Subject: **Revised Request for Modification to Individual Section 404 and Section 401 Water Quality Certification** for the proposed construction of an extension of SR 1163 (Old Georgetown Rd) from SR 1184 (Ocean Isle Beach Rd) to NC 179 in Brunswick County, State Project 6.231023, TIP R-3432. Debit \$570.00 from WBS 35501.1.1

The purpose of this letter is to revise the permit modification request, dated October 1, 2015, for the above referenced 404 Permit and 401 Water Quality Certification. Please replace the permit drawings provided with our latest request with the enclosed revised copies.

**WETLAND & SURFACE WATER
PERMIT DRAWING
REVISED 10/08/2015**

PERMIT DRAWING
SHEET 9 OF 29
REVISED 10/12/2015

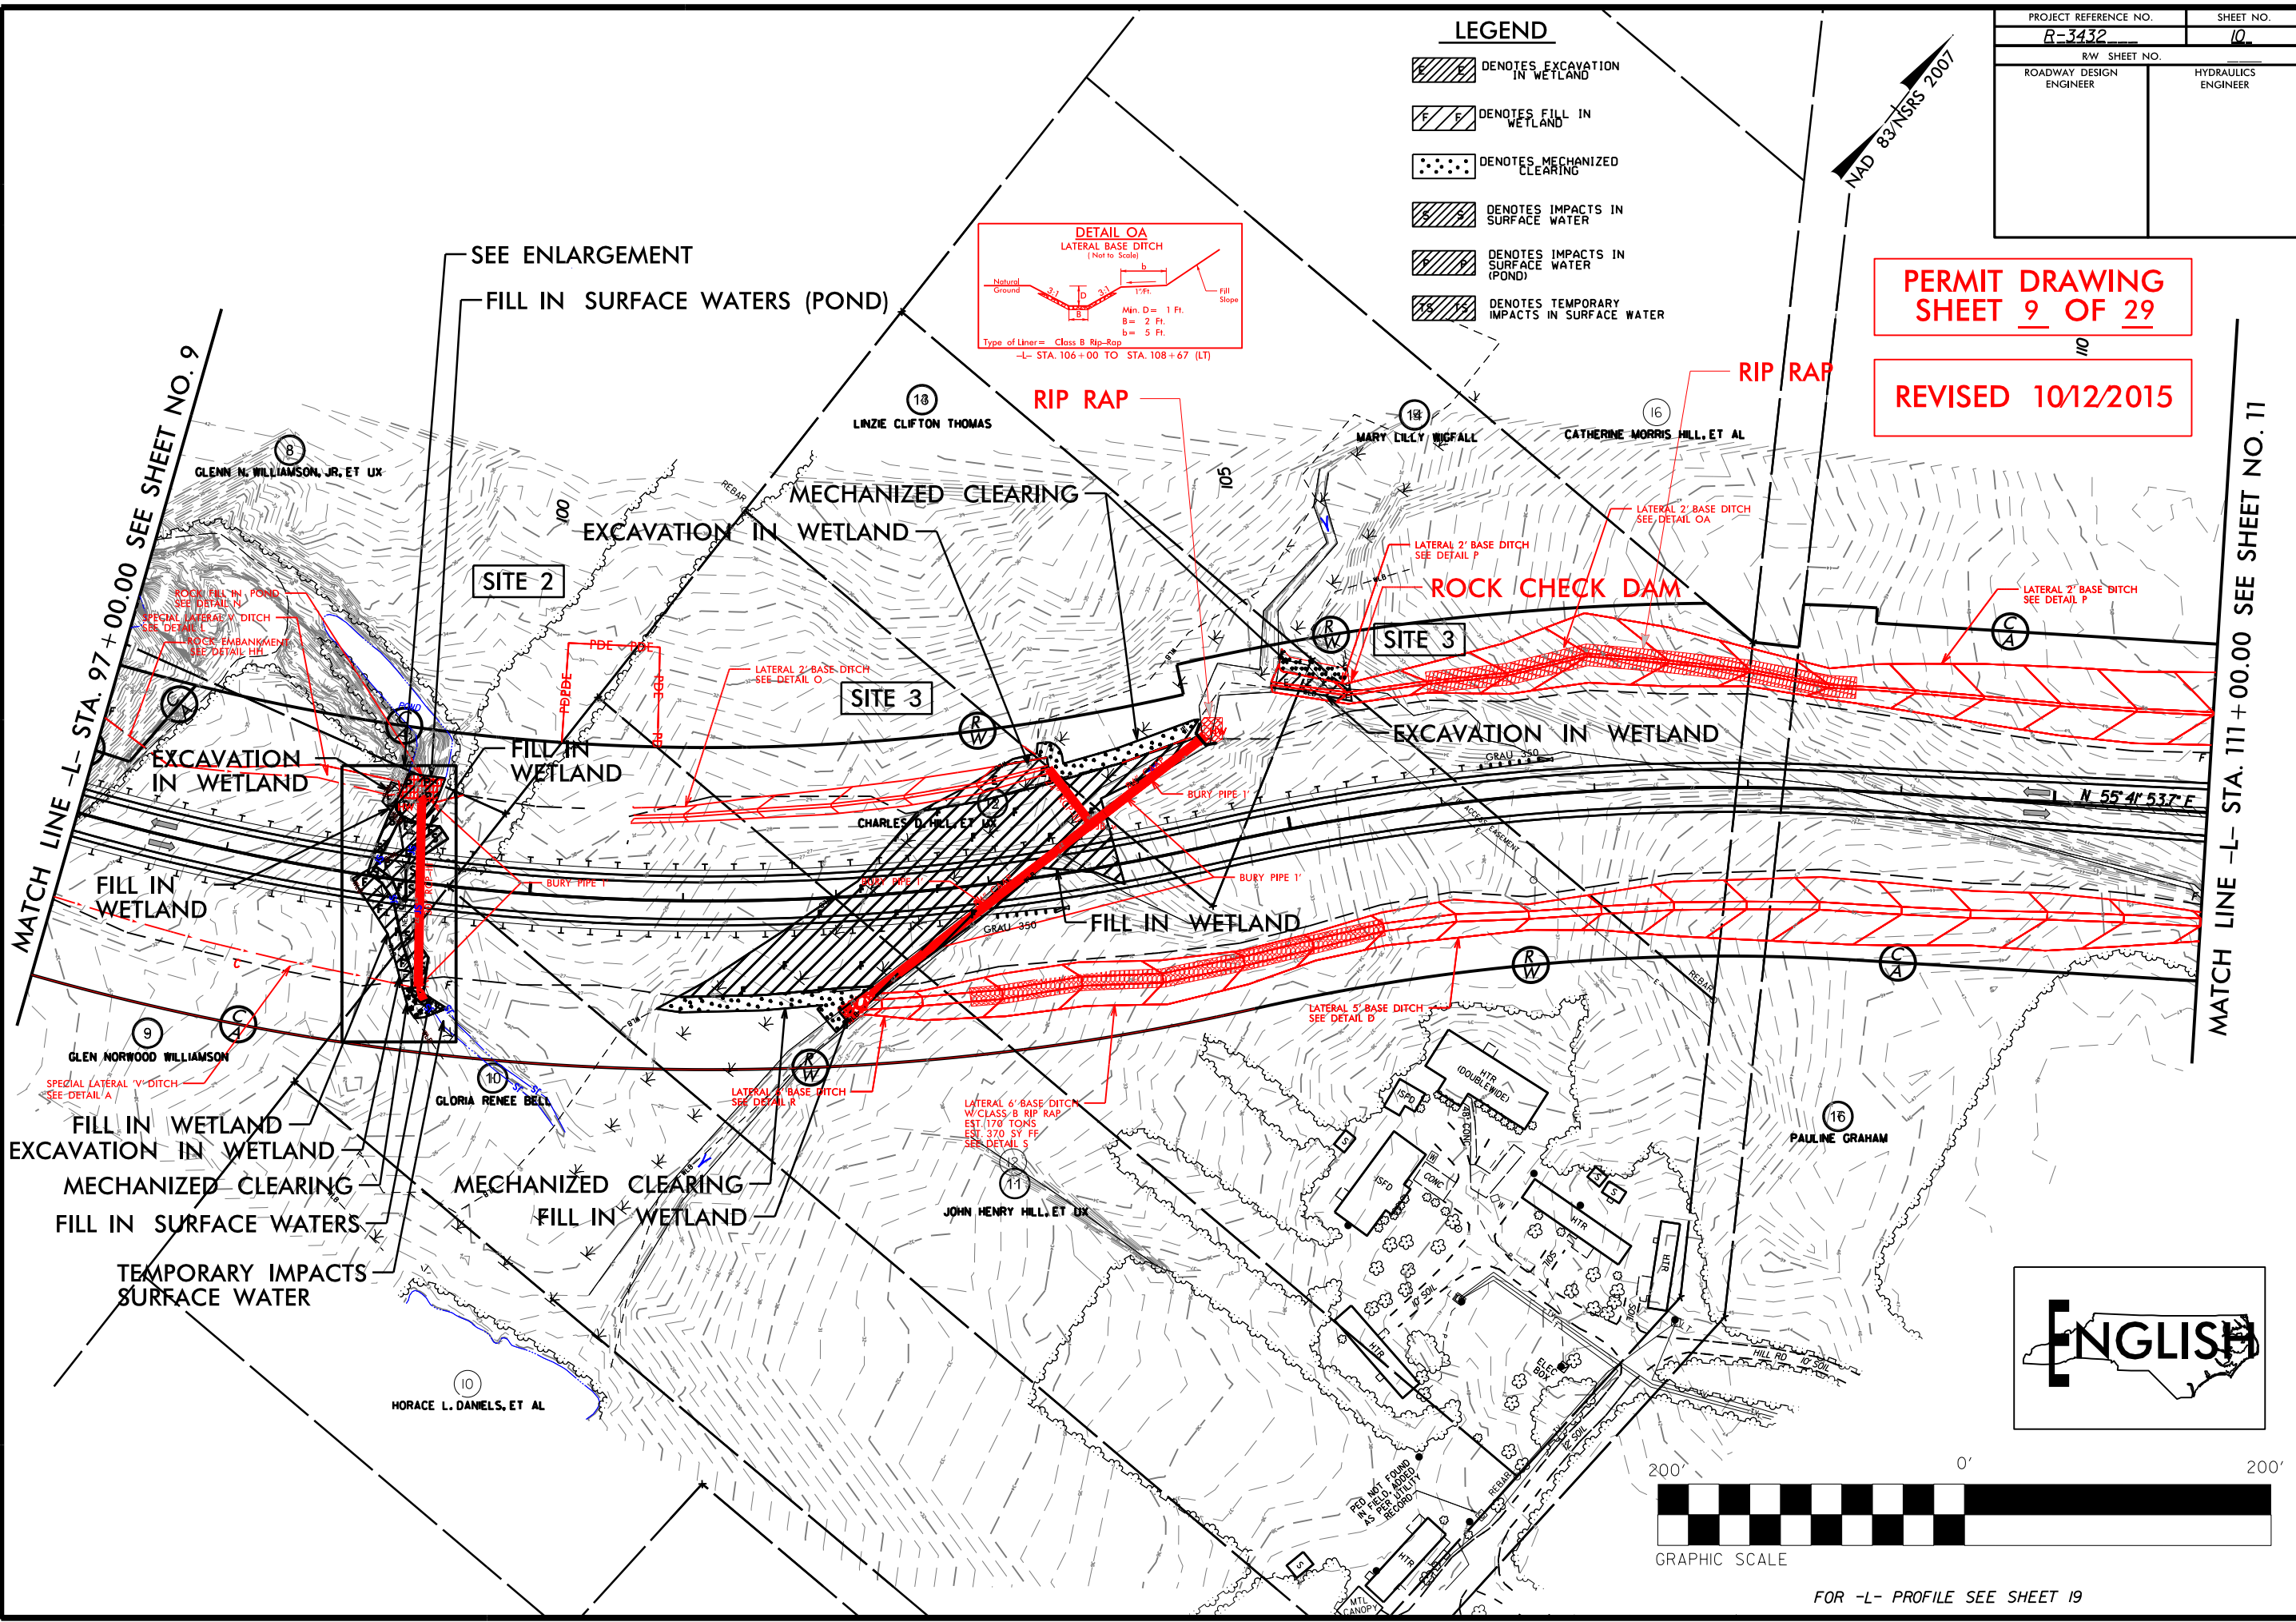
- Site 1. Additional riprap will be added at the inlet of the 84" CAAP. Surface water impacts will increase by 0.1 acre;
- Site 2. The ditch block and special lateral ditch from Site 2 to the ditch block at 100+50 LT will be removed. No additional impacts to jurisdictional resources;
- Site 3. Riprap will be added to line the ditch from Station 106+00 to 108+67 LT, additional riprap will be added at the inlet of the main culvert to fill in the hole

created by construction of the culvert, headwall, and wing walls. There are no additional impacts to jurisdictional resources;
